Consultation Response from KC, Conservation & Design**2023/91970 and 2023/91971 - 114A Fitzwilliam Street, Huddersfield, HD1 5PH****Change of use, alterations, part demolition of boundary wall and erection of two storey side extension to convert from hot food takeaway to residential (Listed Building within a Conservation Area)****Listed Building Consent for Change of use, alterations, part demolition of boundary wall and erection of two storey side extension to convert from hot food takeaway to residential (within a Conservation Area)****Date Responded: 16.08.2023****Responding Officer: SP****Responding Ref:**

Drawing  
Proposed Floor Plans

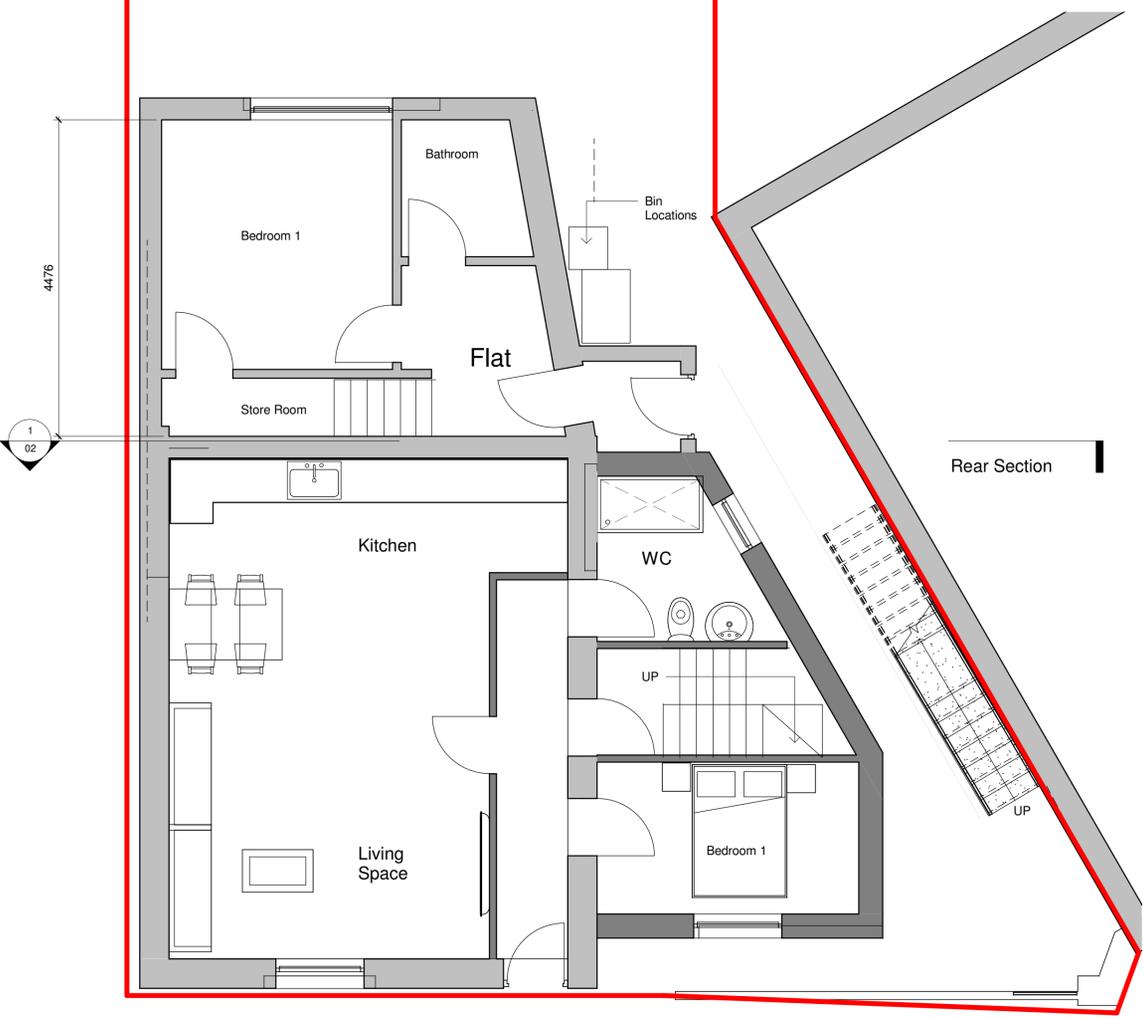
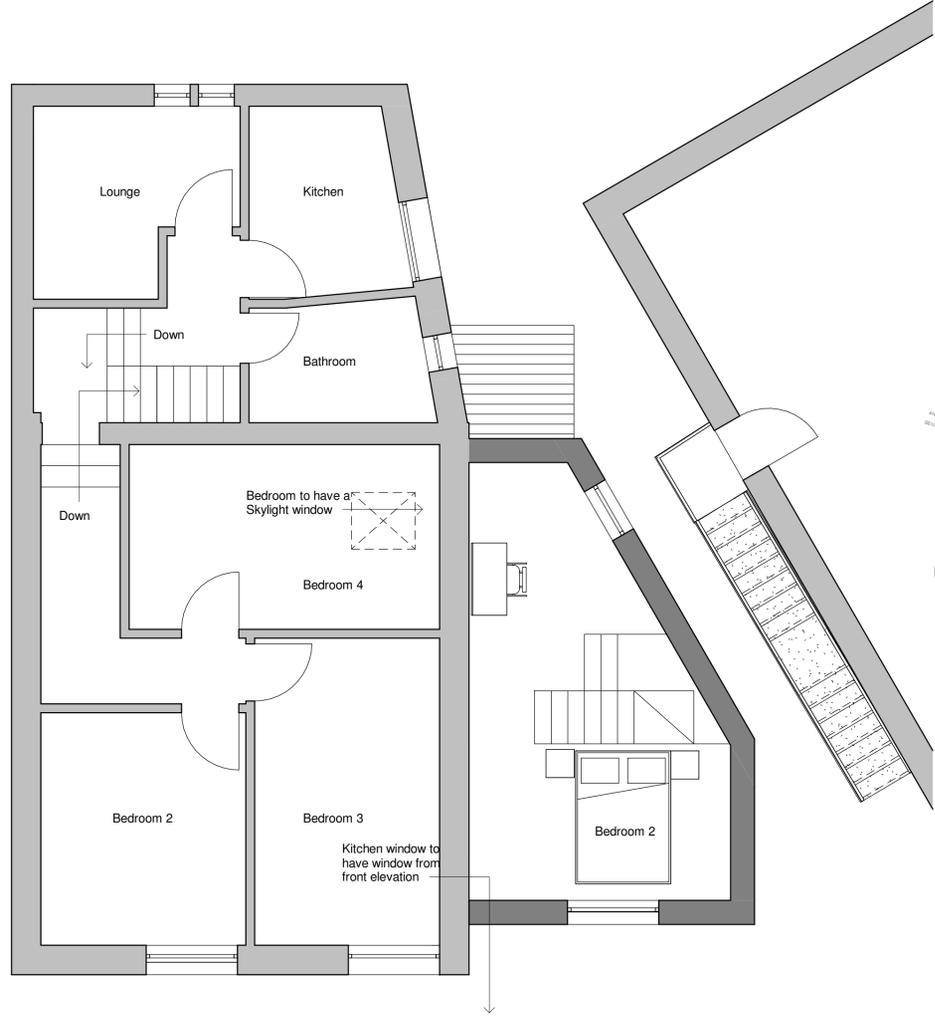
The new proposal still seeks to erect a large two-storey side extension. There have been some minor changes from the previous submission. The front boundary wall is now shown as being retained and the extension has been slightly reduced in size, but this isn't a significant reduction. The height has also been slightly reduced, but again, this is only a minimal reduction. While there have been some minor changes, they do not overcome our overriding concern, which was the principle of such an addition. As we previously set out the side elevation could be enhanced and tidied up without the need for development. The building could also be reused and repurposed without the need for such substantial alterations and additions.

As we previously established, the proposed side extension would not form an enhancement or better reveal the significance of the building but would create a highly obtrusive element for which there is no justification or substantial benefit that would outweigh the considered harm to the building.

We would again set out that we could support the principle of the change of use of the building. We would however restate our objection to the proposed two-storey side extension. While there have been

some minor amendments, these do not overcome our objection to the overall principle of such an addition. There is no clear convincing public benefit or justification for the proposed extension We consider that in its current form, the proposals are unacceptable and do not accord with policies LP24 or LP35 of the Local Plan. Equally, the proposed are contrary to policies 16(2) and 72(1) of the Planning (Listed Building and Conservation Areas) Act. The proposals also do not meet the requirements of Sections 16, 199, 202 or 206 of the NPPF.

As expressed, we could support the change of use of the building, subject to further detail and understanding of the internal works. However, we would again set out that the side extension should be omitted from the proposals, or the application should be withdrawn or refused.
